November 19, 2013

Jean Fraser
Planner
Planning Department, City of Portland
389 Congress Street, 4th Floor
Portland, Maine 04101

As you are aware, our plans for the Munjoy Heights project have evolved substantially since our initial October 22nd workshop. We have attempted to address each of the questions, issues, and concerns raised by City Staff and by the Planning Board at the October 22 workshop. In preparation for the upcoming November 26th workshop, this letter will summarize the issues raised and how we have addressed them in our current and updated plans.

DRAWING NO. C-30

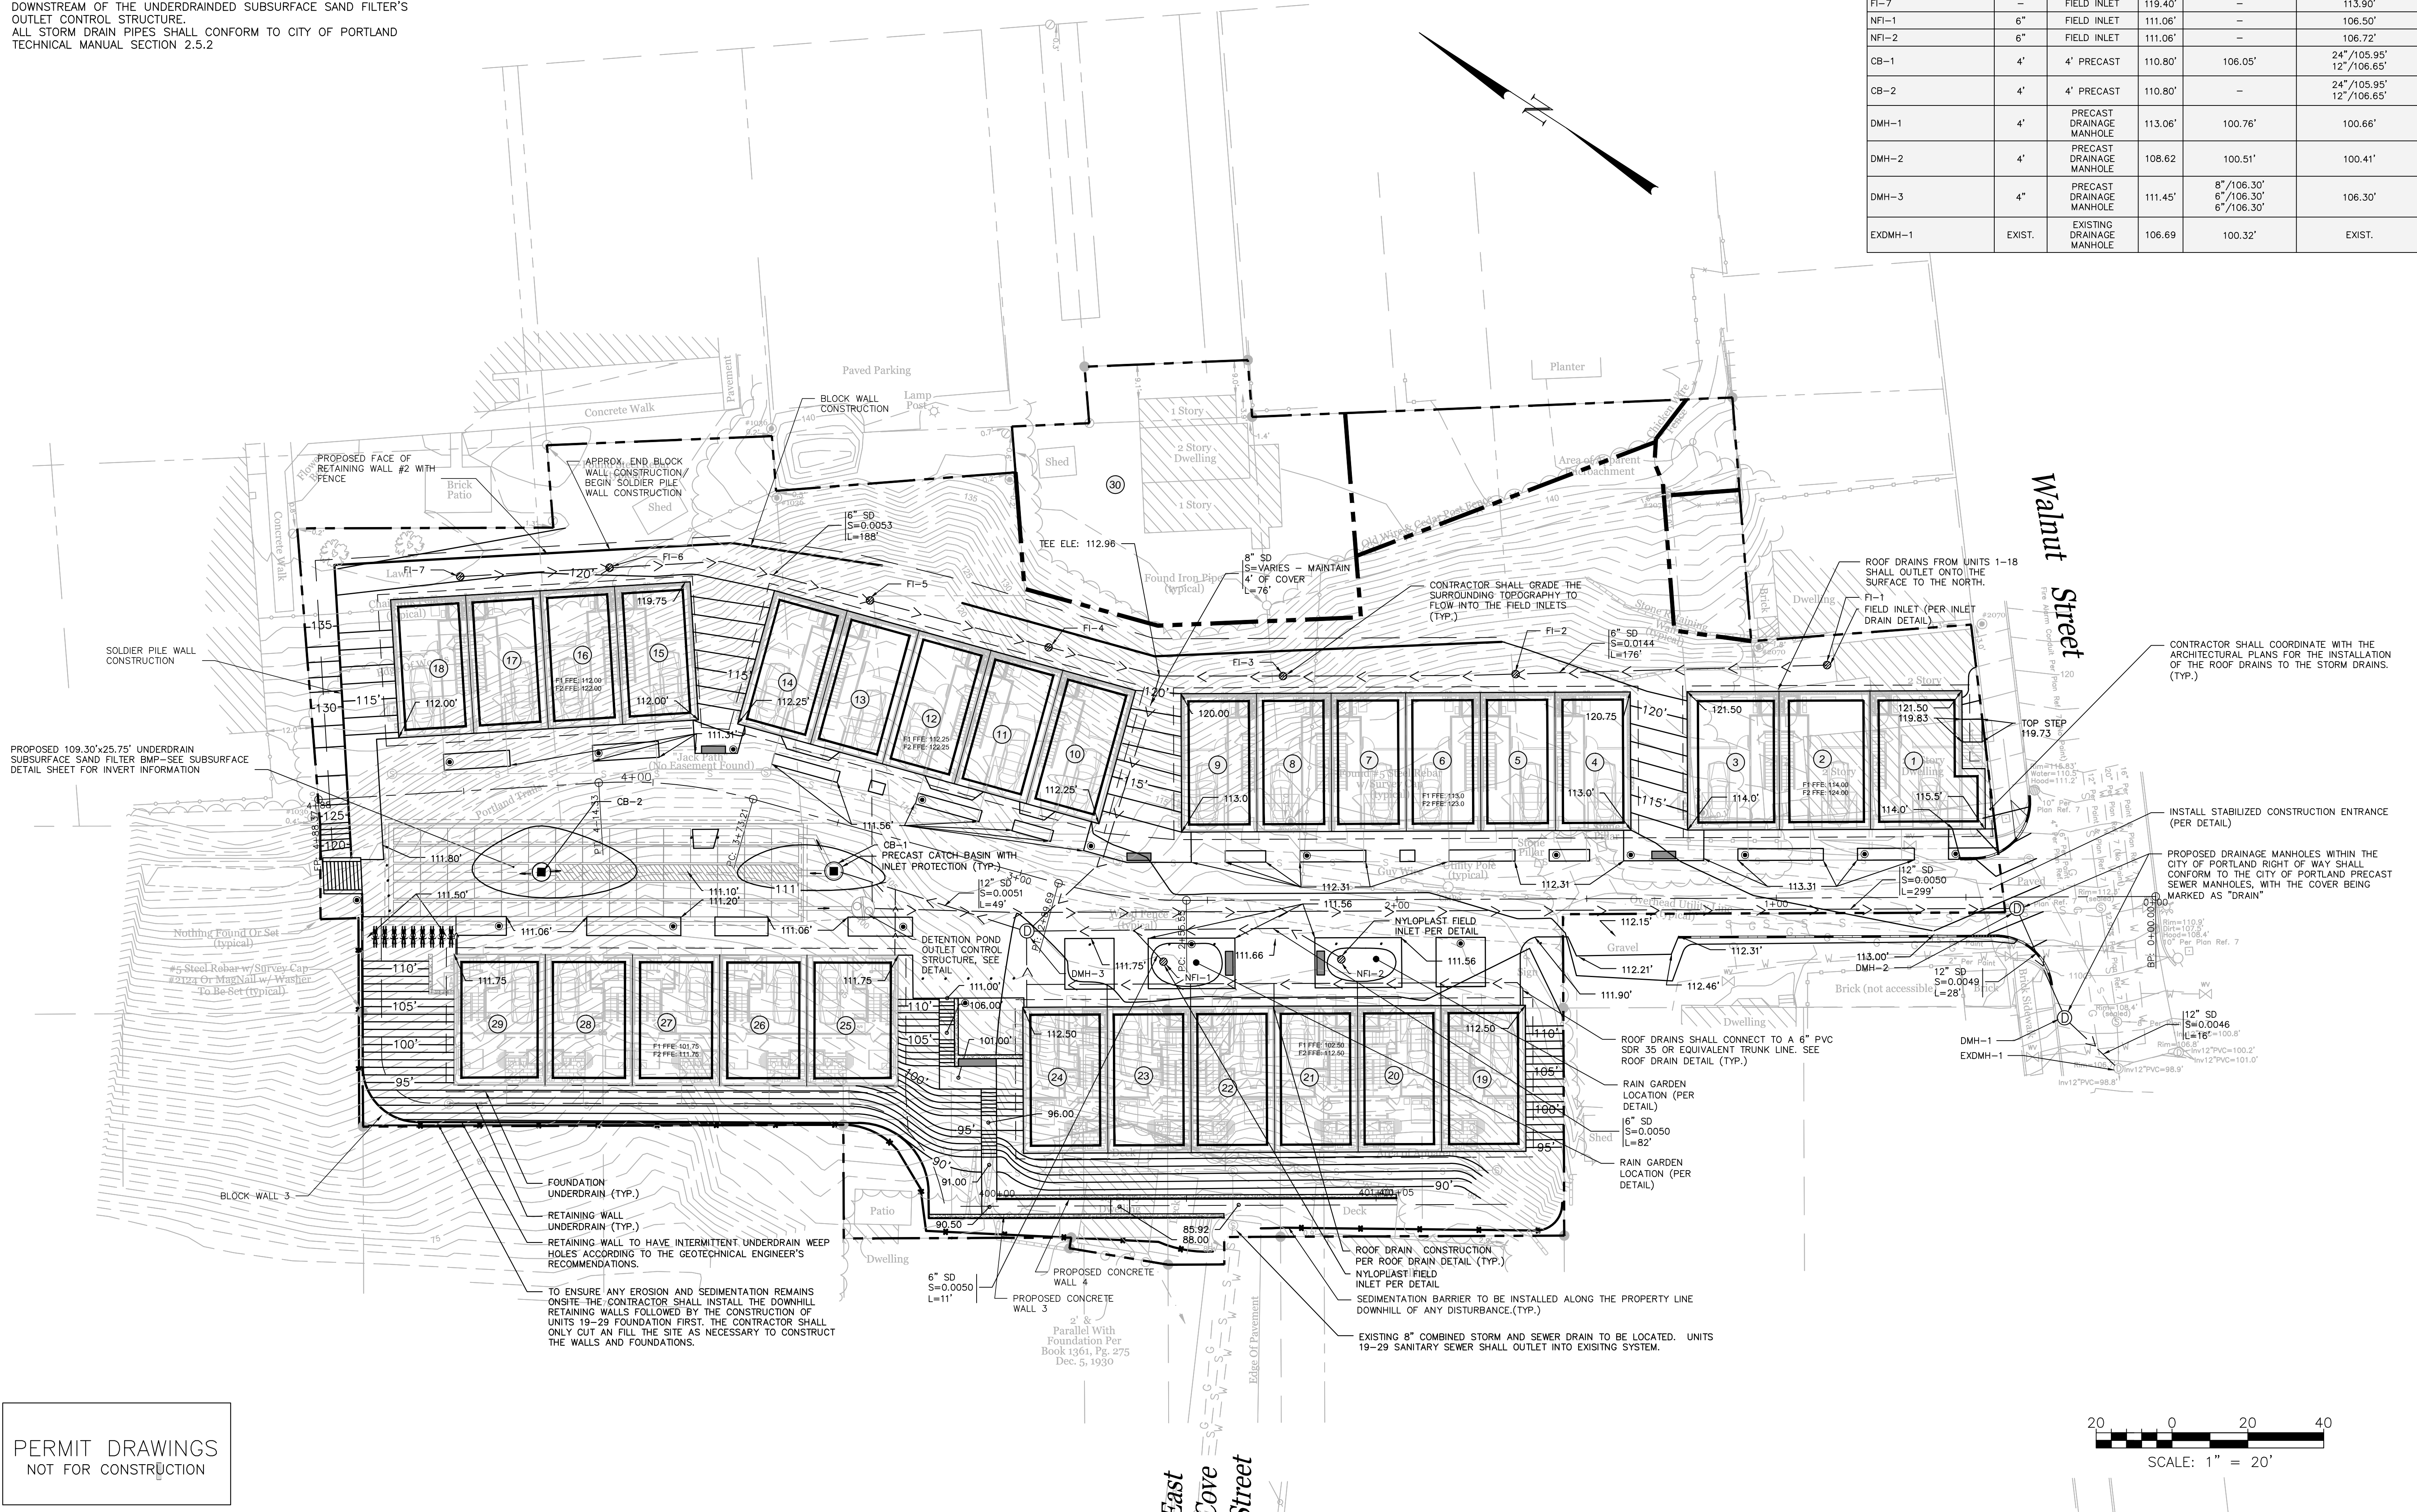
Erosion Control Concerns (particularly during Construction)

In conjunction with Wright-Ryan Construction, the project's construction manager, we have developed detailed Construction Management Plan, in addition to the Grading, Drainage, and Erosion Control Plan (Drawing C-30). These drawings have been submitted separately. To properly manage erosion during construction, construction will be sequenced as follows:

1. Install a stabilized construction entrance in all locations where construction traffic will enter and exit the site.
2. Install perimeter silt fence or erosion control berm.
3. Install all other erosion control devices as necessary throughout the remainder of this schedule
4. Commence the installation of the downhill retaining wall(s).
5. Commence the installation of the down gradient foundation and wall for Units 19-29. Cut and fill only as necessary to backfill the retaining wall and foundation wall as designed within the appropriate plan(s).
6. Commence remaining earthwork operations, wall and foundation installation.

L2.0
 PLANTING PLAN

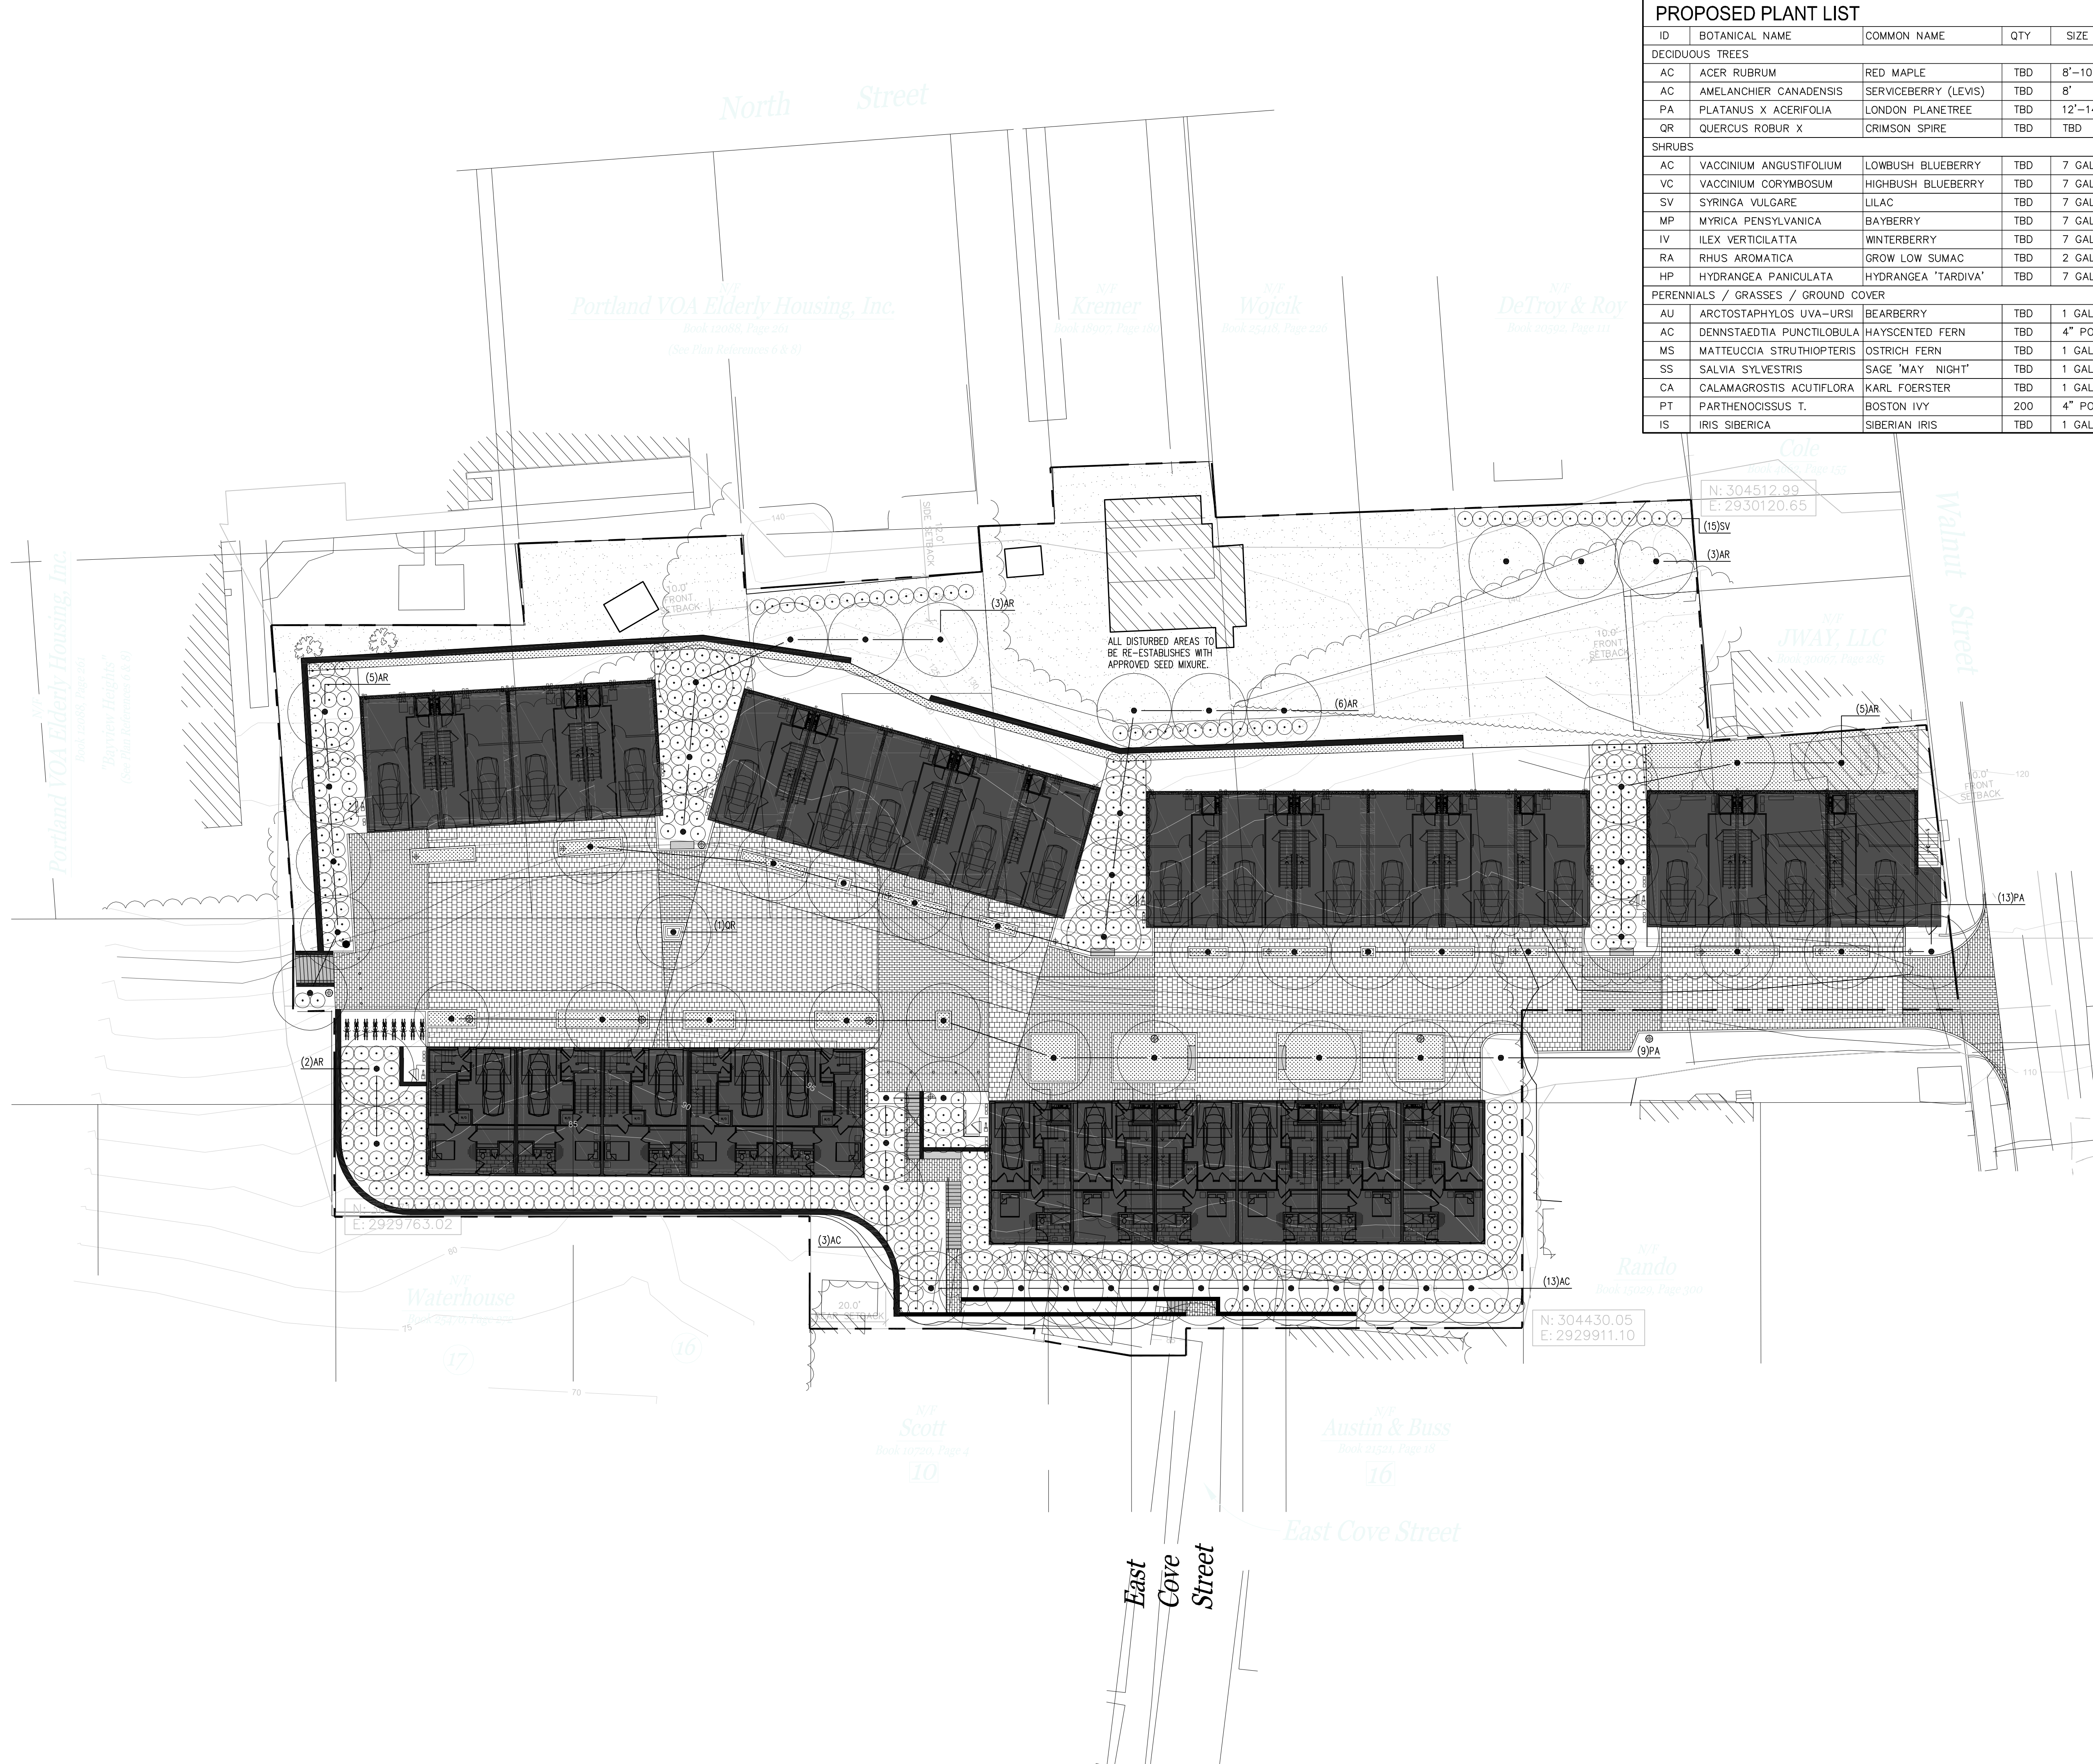
Many stakeholders, including the Planning Board, at the October 22nd workshop, have expressed concern about the loss of trees, and have emphasized the importance of ensuring a healthy vegetated environment.

Our landscape plan focuses on aggressive planting of trees and shrubs, well beyond the requirements of the Ordinance. The updated Landscape Plan contemplates planting 67 new native specie trees and many more shrubs. The planted shrubs will cover nearly the entirety of the unbuilt space (roughly 27,165 square feet). The re-vegetation strategy proposes native plants in densely planted woodland gardens that mimics native forest plant communities. Plant selections and spacing will reduce erosion, lower long term maintenance, cut water costs, and provide wildlife habitat. We expect that the transition from invasive species to native plants and trees on the site will lead to improved ecological health for the neighborhood and City. Plant list and placements can be found on drawings L1.0 and L2.0.
